Question

Kippure Lodge and Holiday Village,
Kippure Estate, Manor Kilbride,
Blessington, County Wicklow.

Wicklow County Council

EX53/2024

3 02 Rear Elevation
1 : 100

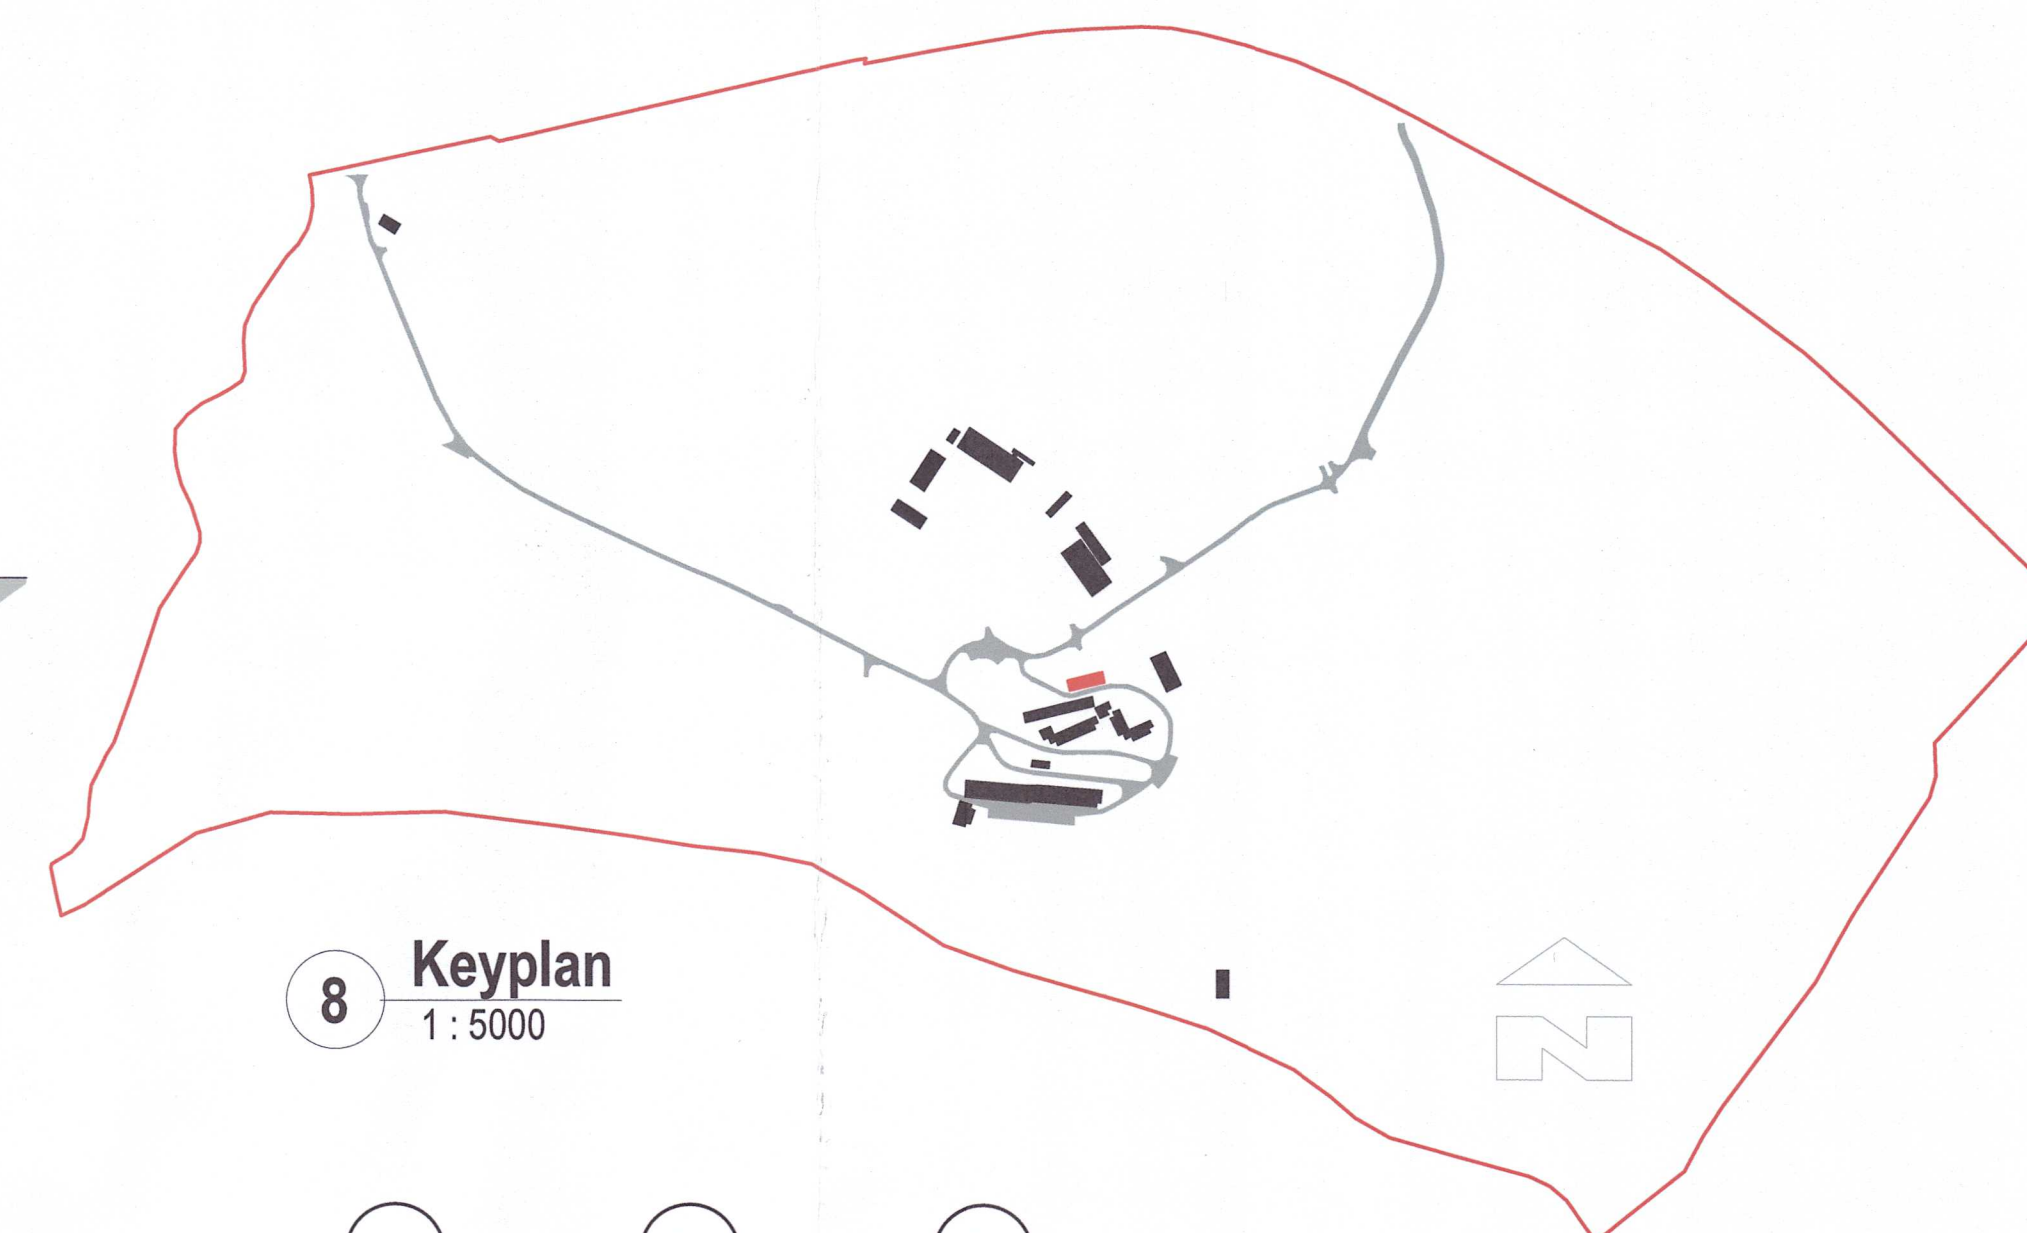
This building was constructed in c. 1830 and predates the Planning Acts and modern planning law. The structure has been upgraded and renovated as exempted development under Section 4(1)(h) of the PDA. Permission was also granted under Reg. Ref.05/2792 for the refurbishment of the Belfry Building and its use as a backup facility for outdoor facilities.

The structure has been extended and altered by reference to changes in height, length and width. The nature of the works would not comprise maintenance, improvement or other alteration and result in the structure being materially different to the former structure. The works have significantly altered the external appearance of the structure so that it is inconsistent with the character of the structure.

There are no exemptions under the PDR.

There are no other exemptions available for this structure. Therefore, it is development and is not exempted development.

Structure 12

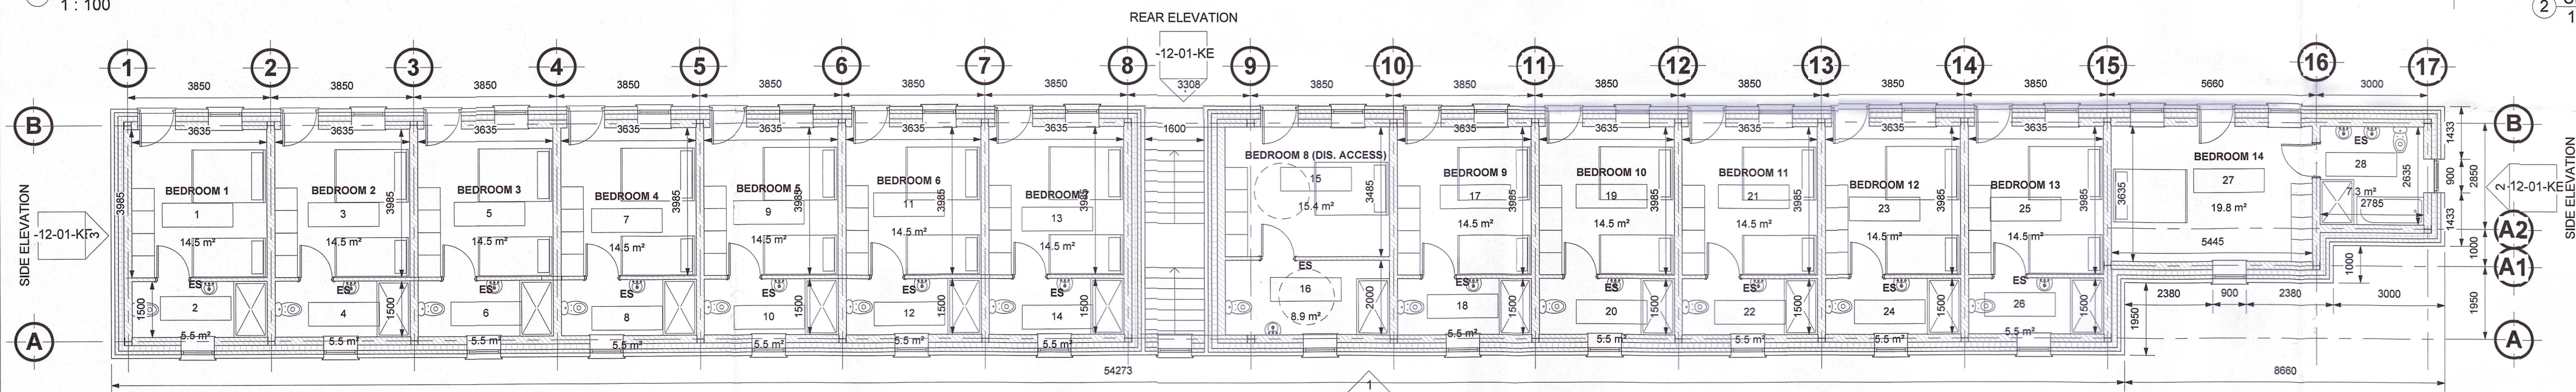
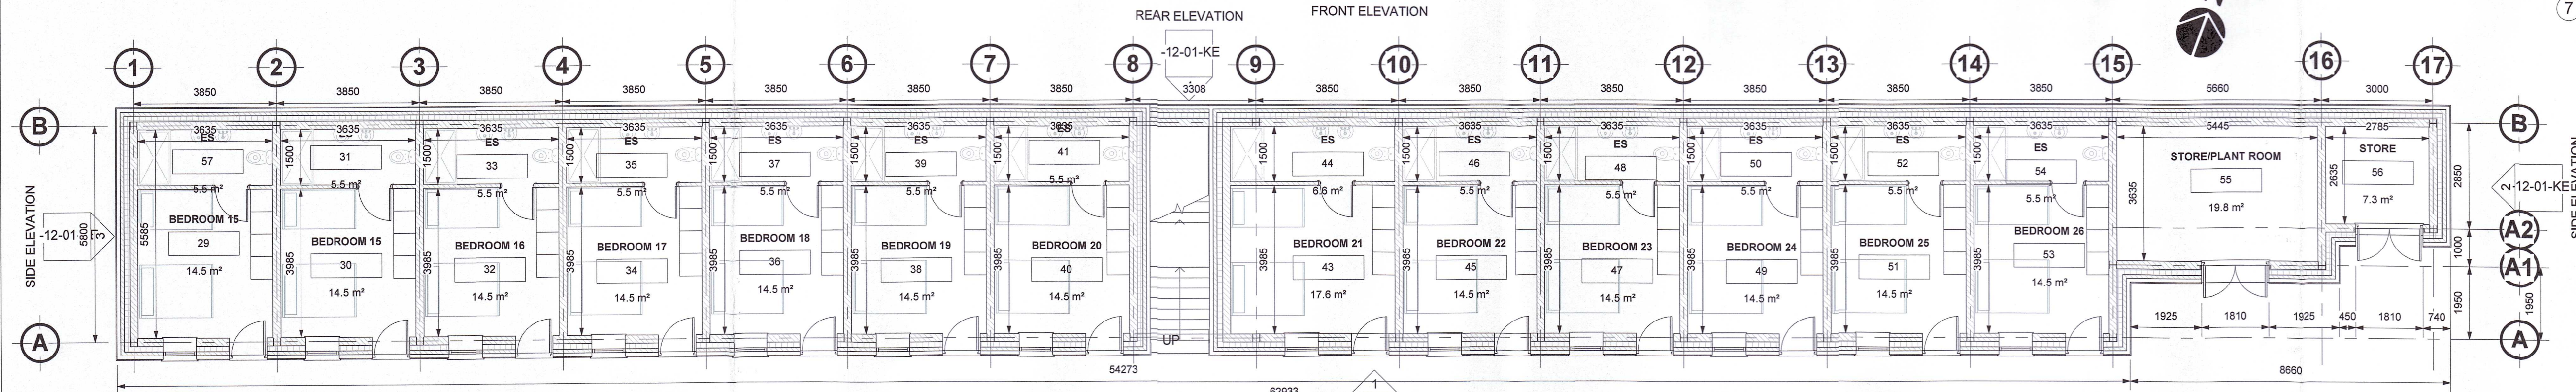
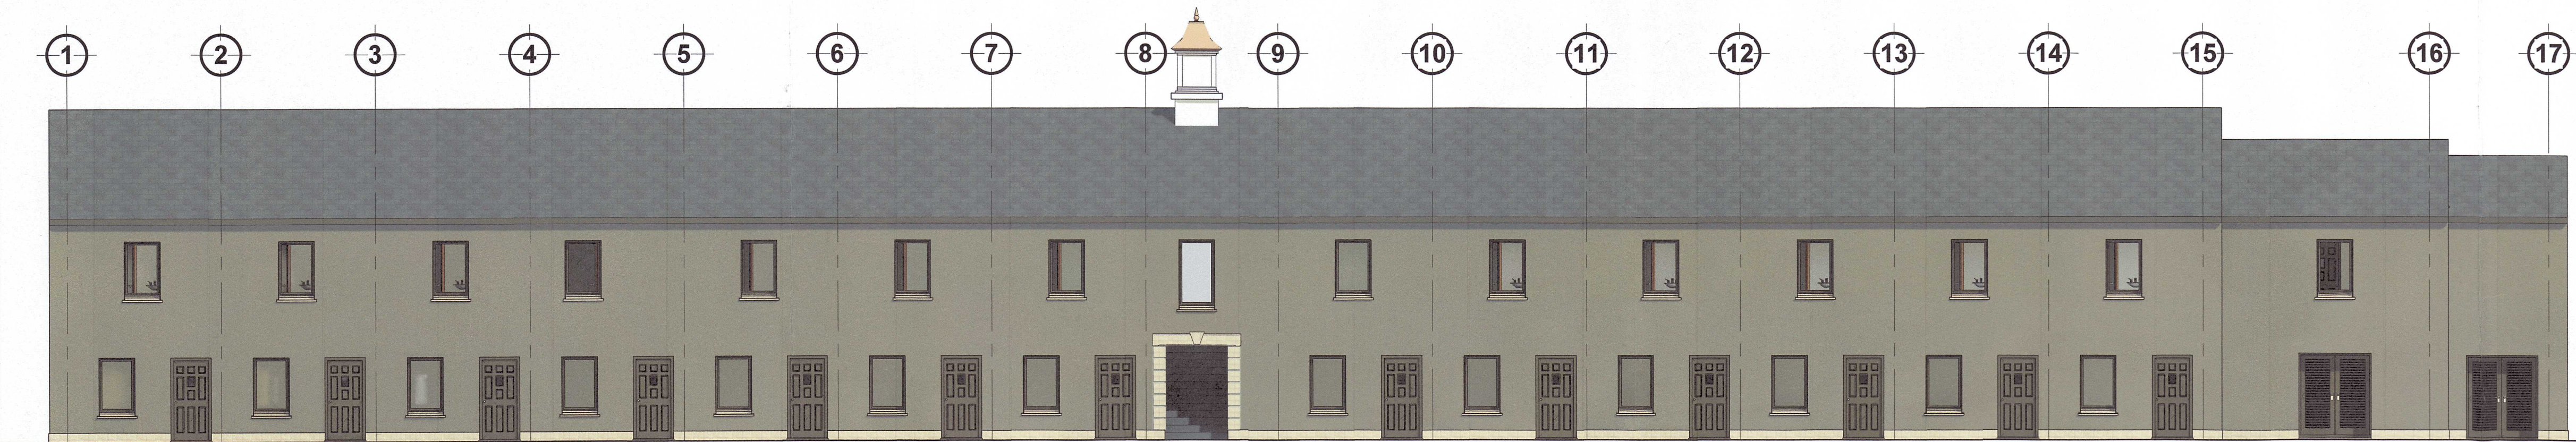
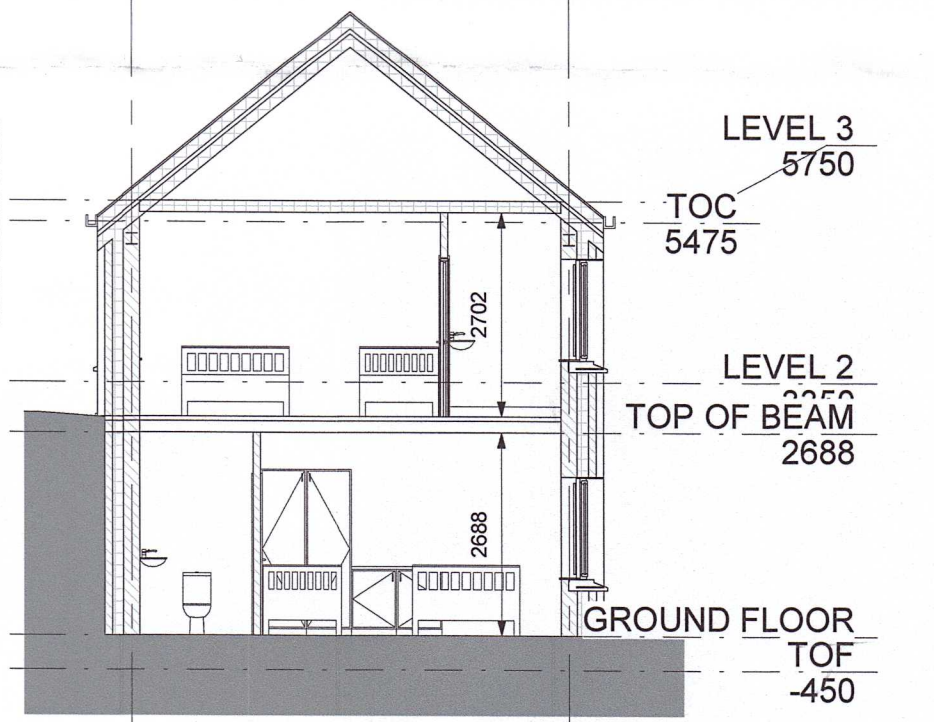
It would appear from drawings submitted with Reg. Ref. 99/1150, aerial photography and photographs from 2011 / 2012 that the Long Barn is not Structure 12. In addition, aerial photography from 2020 shows there are no structures within the location to the north of the holiday homes, the retained structure (Reg. Ref. 99/1150) and Structure No. 10: The Belfry. Therefore, it is considered that Structure No. 12 is a newly constructed accommodation unit.

The structure comes within the meaning of works and would therefore come within the meaning of development as provided for in Section 3(1) of the PDA. There are no exemptions in the PDR that would apply to Structure No. 7 and Structure No. 8.

Section 4(1)(h) is not applicable as this is a new structure.

This structure is development and is not exempted development.

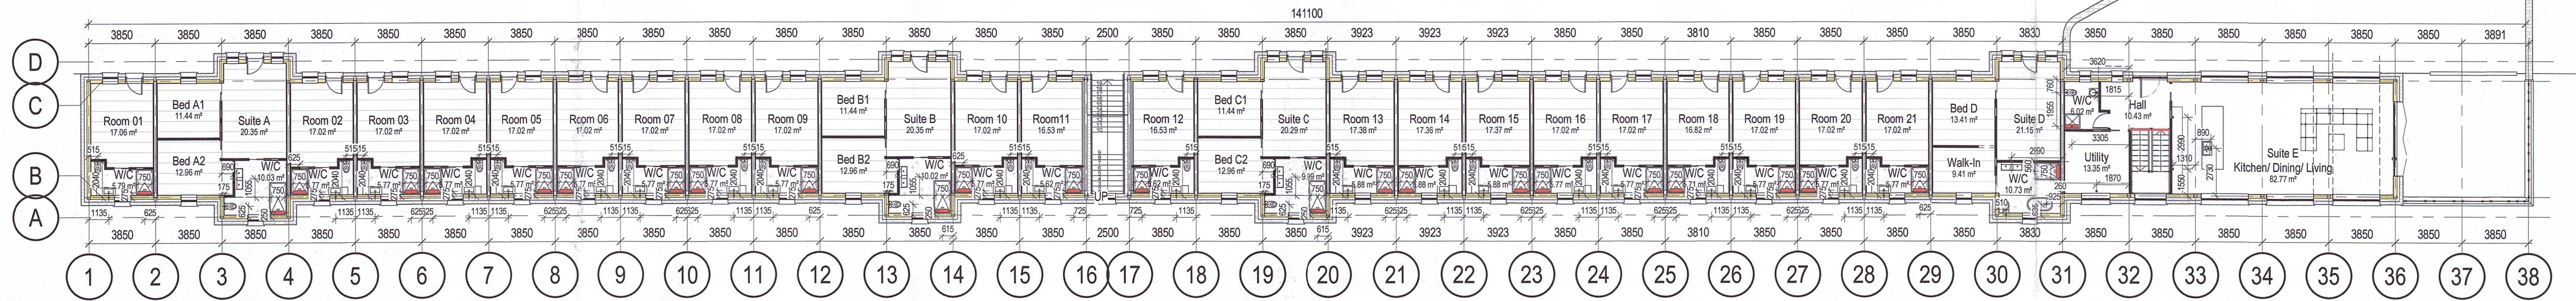
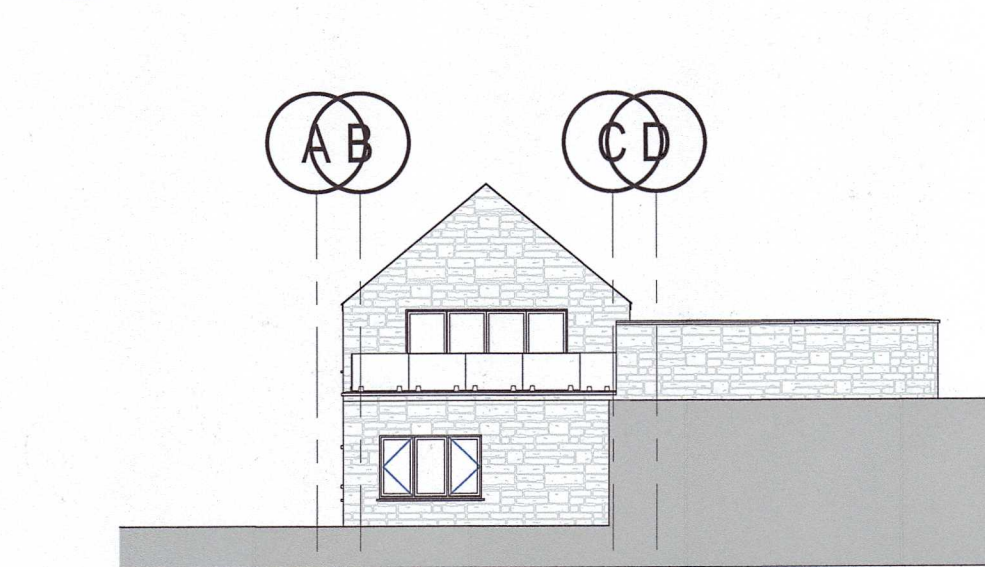
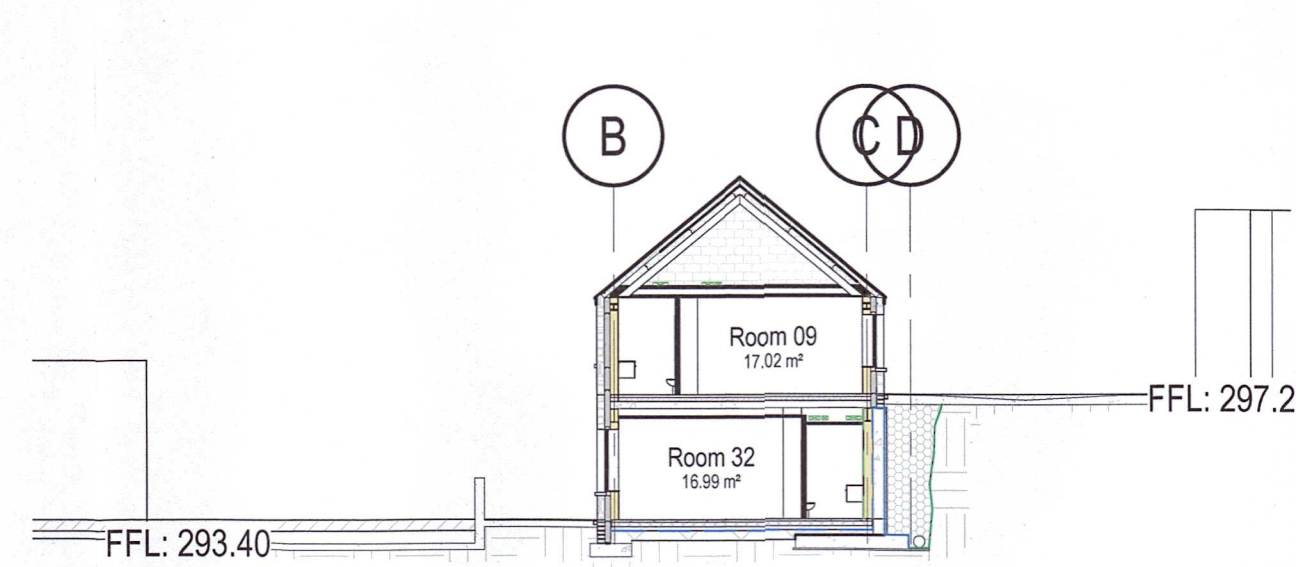
This structure also referred to as The Stables and Grain Stores was constructed in c. 1830 and pre-dates the Planning Acts and modern planning law.

Information submitted with Reg. Ref. 12/6539 indicates that the 'existing shed' was a minor structure being limited in scale. The information provided with the submission indicates that Structure 16 is a modular building, and its principal components were manufactured off site, with the building assembled on site and fixed with bolts to a pre-constructed reinforced concrete retaining wall.

The structure comes within the meaning of works and would therefore come within the meaning of development as provided for in Section 3(1) of the PDA.

Section 4(1)(h) is not applicable as Structure 16 is a new structure. There are no exemptions in the PDR that would apply to Structure No. 16.

Structure No. 16 is development and is not exempted development.
